**From:** Judith Ward  
**Sent:** 28 October 2019 14:33  
**To:** Caroline Ford  
**Subject:** 19/00963/OUT OS Parcel 9100 Berry Hill, Adderbury

**Judith Ward**  
**Landscape Planning Officer**  
Cherwell District & South Northants Councils

Viewpoint 1A: From Berry Hill Road, opposite site entrance, looking north-east

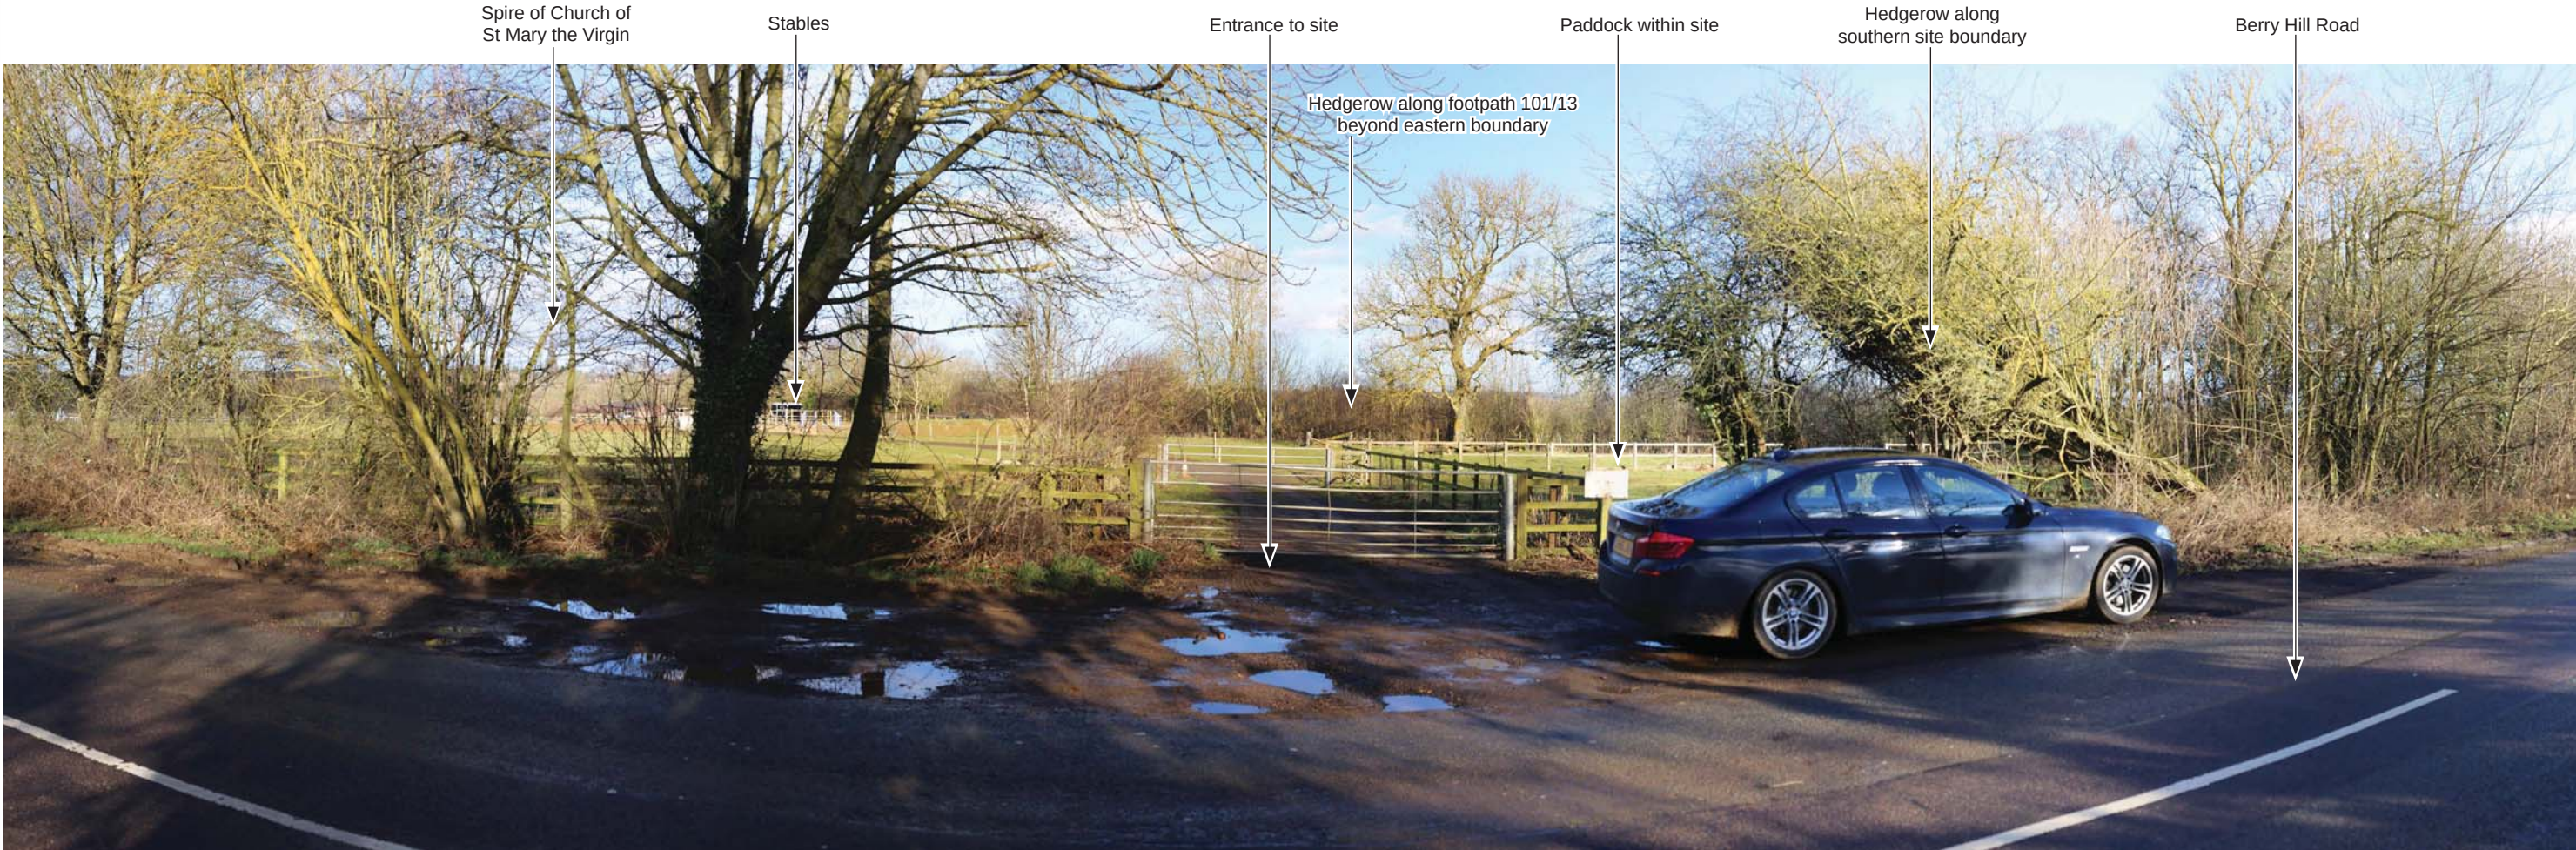
VP1 I am not sure that I am convinced that the slight possibility of the church spire being possibly more visible in this latest proposal is sufficient to reduce the effect of the development.
